John Wetherill (ref 20016217) - Written Representation on the proposed Underpass at Chiverton.

Drawing Title
GENERAL ARRANGEMENT AND SECTION PLANS APFP REGULATION 6(2)(I),(II),(III),(VI)
SHEET 1 OF 8

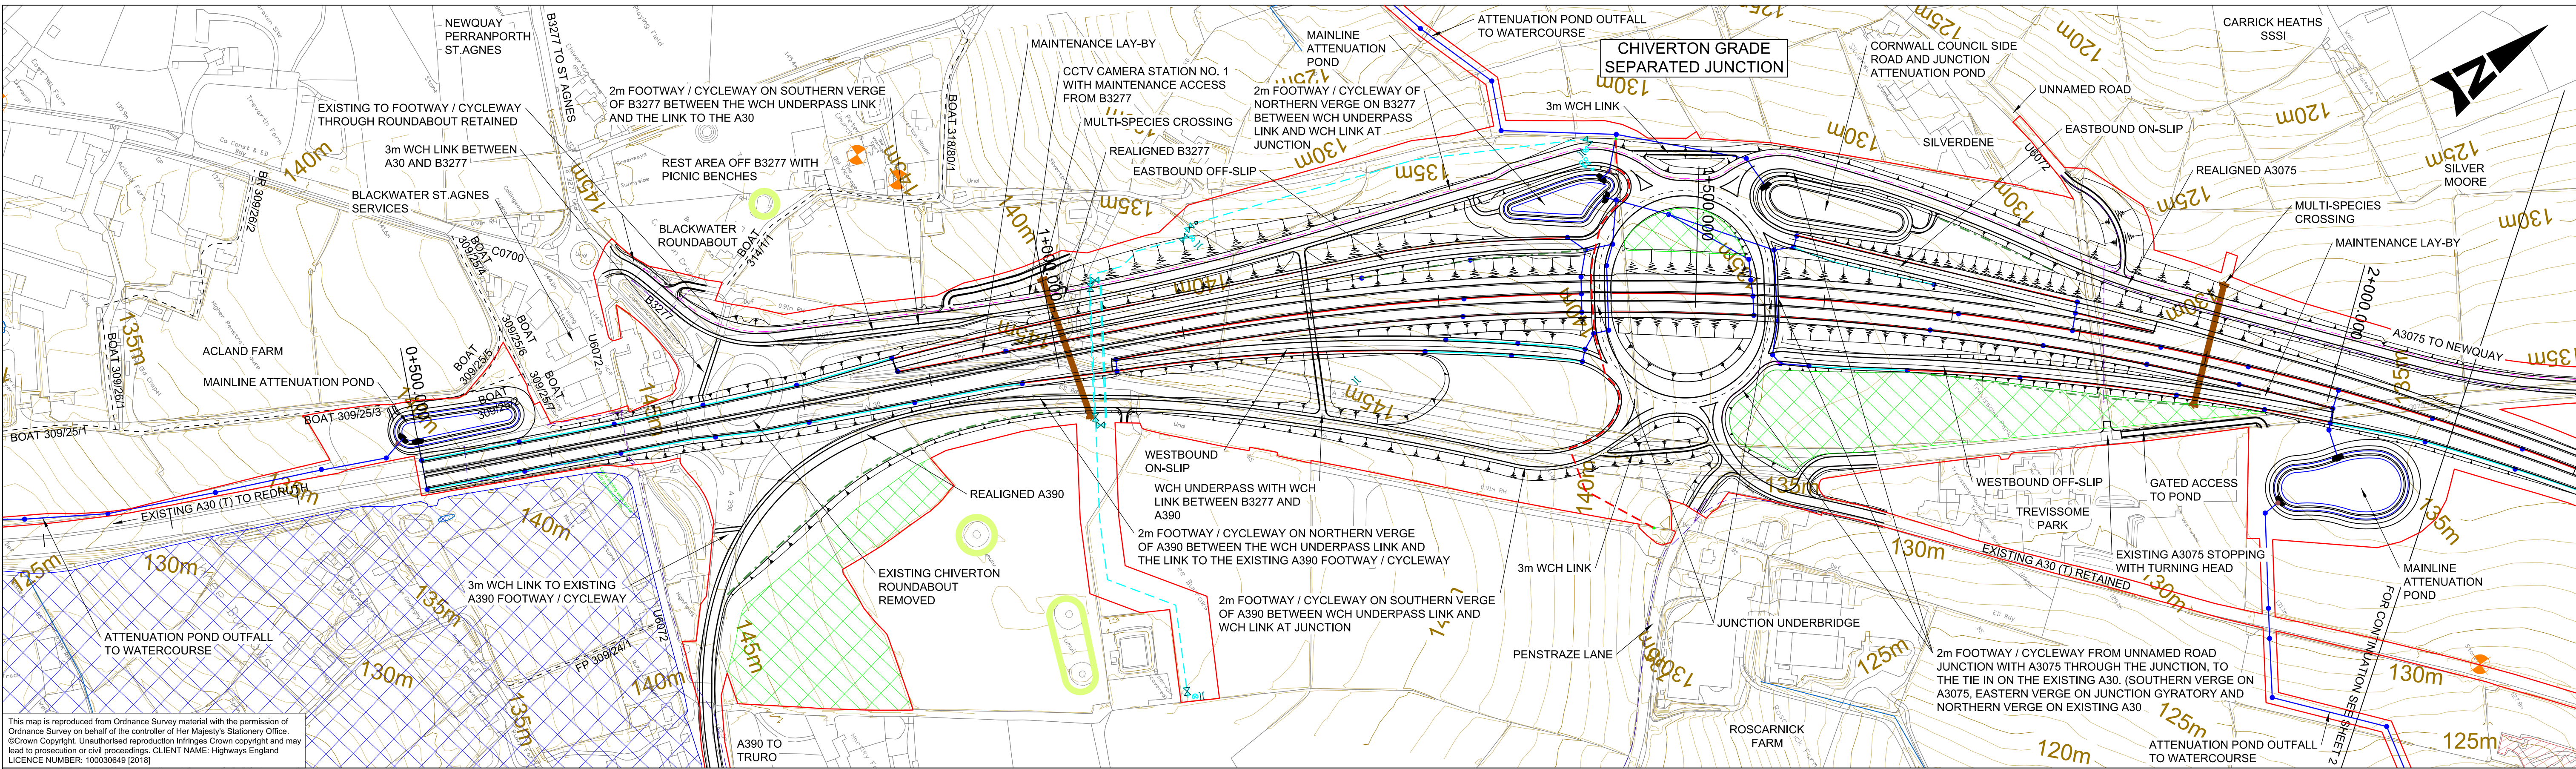
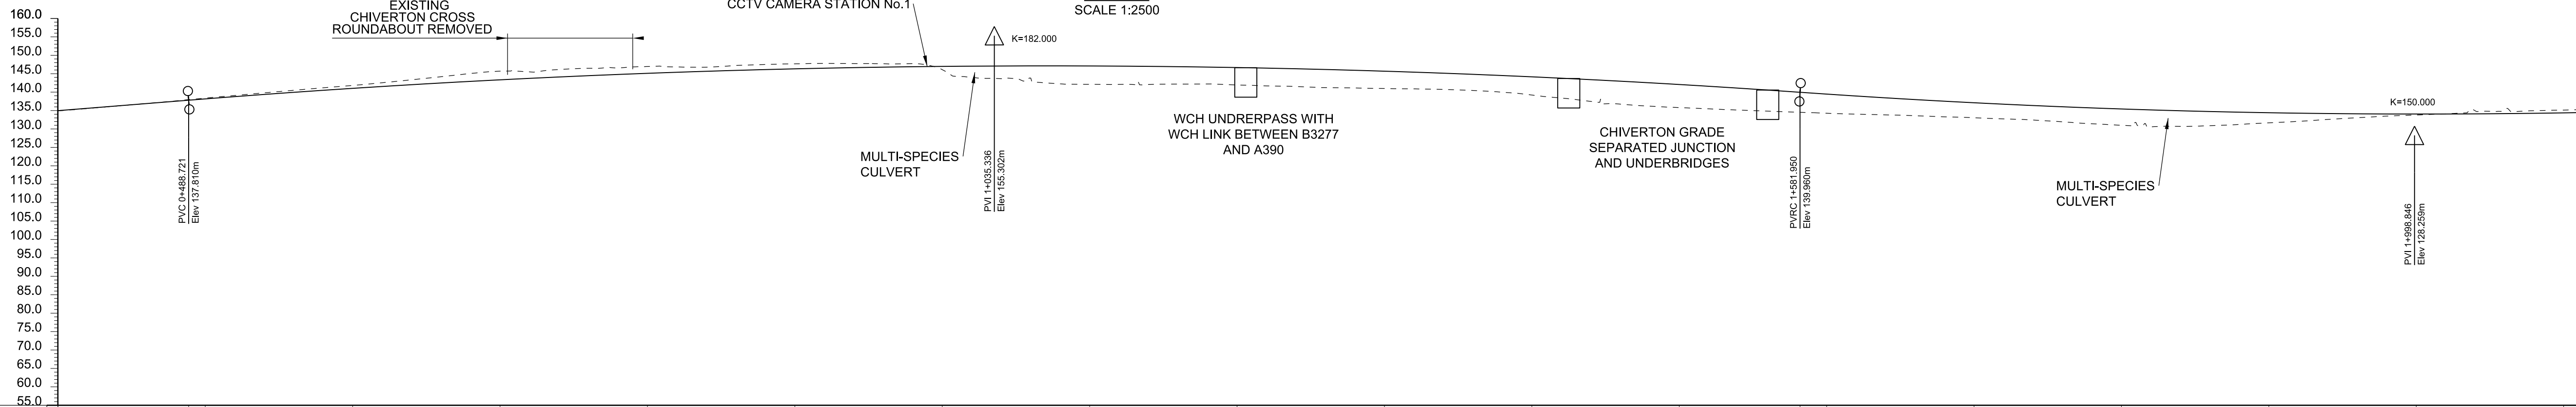
2.4 Moreover these considerations have led to this particular underpass being in an especially isolated position, overly long and of minimum height and width.

4.2 Presumably, also to save on cost it is only 4m wide and only guaranteed to be 2.7m high. Already in a relatively unpopulated area it is further away from the few houses, 2 petrol stations, cafe and public house than a crossing at the present junction site would be. The entrances to the underpass would be some distance from the roads it connects. Judging from the map they would be about 20m from the B3277 and 50m from the A390. This will mean even more that the length of the subway will not be easily in the view of passing traffic which is seen as helping to minimize fears of personal safety in paragraph 2.5 of TD 36/93.

5.1 The width of the proposed underpass is 4 metres. This is less than the 5 metres required to afford segregation of users, as according to HD 36/93 in chapter 4.3. Thus not only is it narrower than the ideal; it will have to be for unsegregated use.

5.2 Chapter 4.7 states that 'Where the number of pedestrians and cyclists is small, an unsegregated subway may be acceptable, particularly for short subways with good through visibility.' This underpass is definitely not short. Also its relative narrowness may limit its usefulness in future years where factors such as housing development or increased cycling rates may require more width or segregation from other users. I

5.3 The underpass only has a guaranteed height of 2.7m. HD 36/93 paragraph 4.10 states 'Where bridleways are to be incorporated into subways, the minimum headroom available should be 3.7m except where suitable facilities for the riders to dismount and remount are provided, when the headroom may be reduced to 2.7m. Thus horseriders would need to dismount to use the underpass.

5.4 Highways England TA 90/05 'The Geometric Design of Pedestrian Cycle and Equestrian Routes' refers to the need to avoid low headrooms over longer distances since horses are more difficult to control when being led. Thus other users and the dismounted rider would be vulnerable, especially considering their closer proximity due to the narrowness of the underpass but it's long length. (moreover HD 90/05 gives a minimum headroom of 2.8m over 'longer distances')

The underpass incurs a 1km detour in comparison to the route on the direct B3277/A390 alignment. IAN 195/16 States ' Directness: Cycle networks shall serve all the main destinations and shall seek to offer an advantage in terms of distance and journey time. ' The longer journey time involved would reduce the number of people able to fit cycle commuting into their daily lives.
